From: Henry Stamp [REDACTED]
Sent: 11 January 2018 17:03
To: Richard Temple
Subject: Objection to planning application reference: BR/194/17/PL

I write to Object to the above planning application for new toilets and foreshore office on the Promenade as part of the recent re-consultation following changes to the proposals with additional and revised supporting information submitted.

DRAWING
Proposed Toilet Elevations

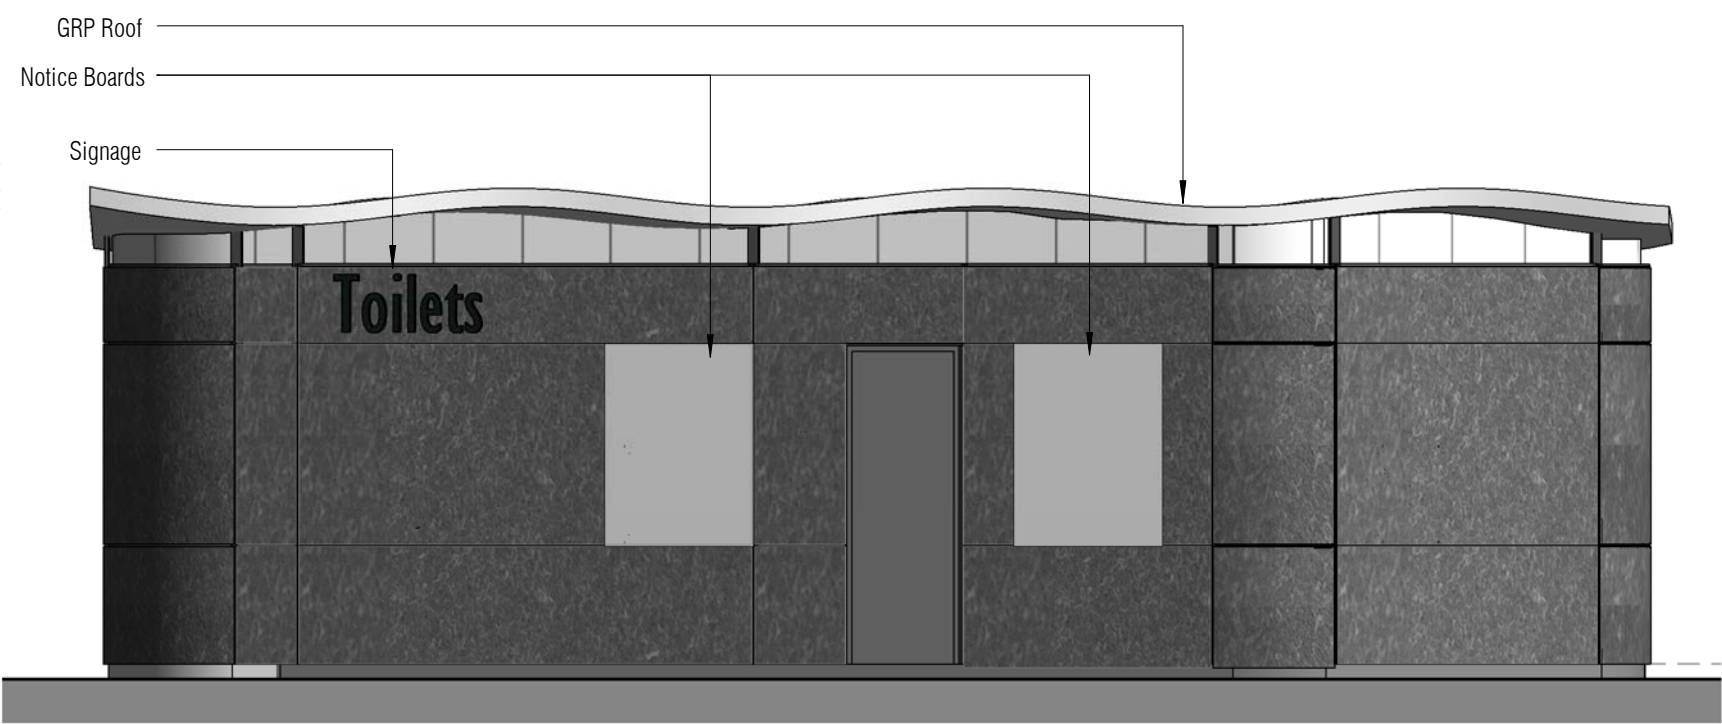
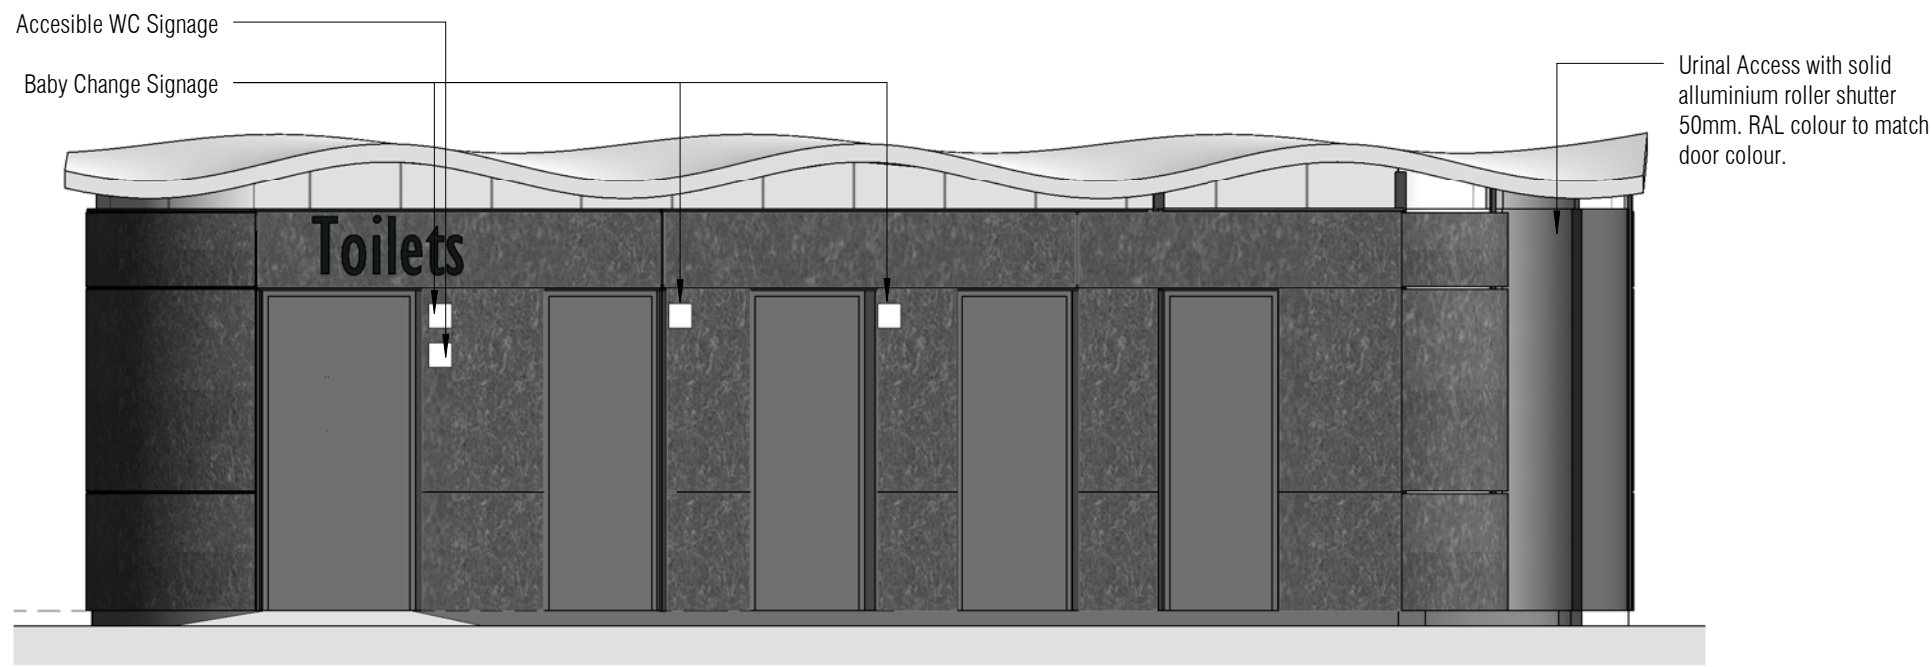
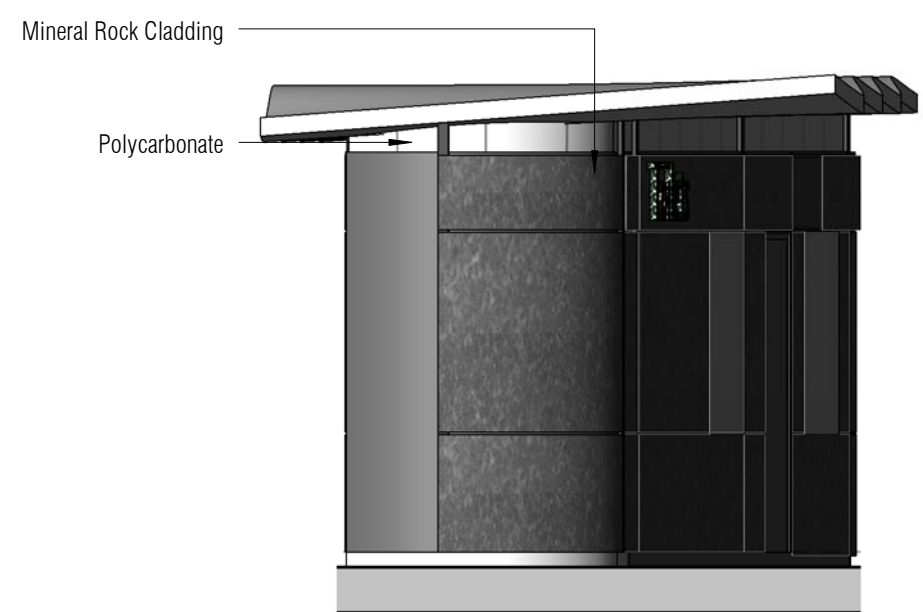
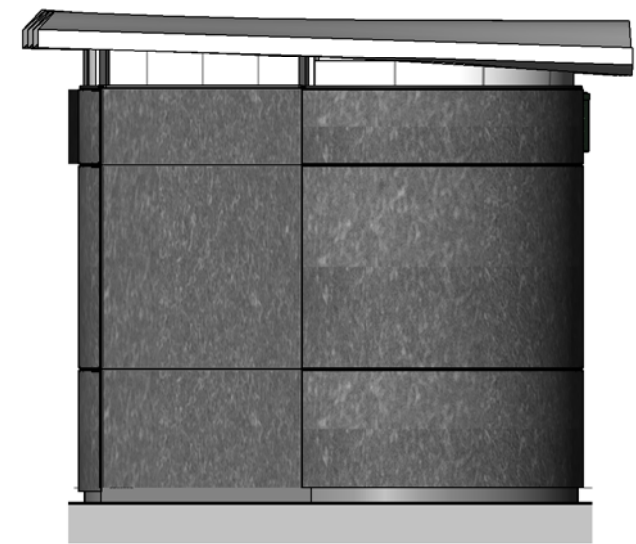
Changes to place the public toilet doors on the southern elevation are welcome. Well done.

- by removal of proposed clerestorey glazing, and the lack of other environmentally beneficial features (like PV on the roof or grey water harvesting for toilet flushing), the new buildings will not add to the achievement of sustainable development;

- the designs are out of context with their surroundings, both buildings on the Esplanade to the north (especially the Esplanade Grande) which will be the backdrop to views from the Promenade, and views along the Promenade by people (including visitors/tourists) walking along the Promenade in both directions westerly and particularly easterly - in the context of other buildings located on the Prom.;
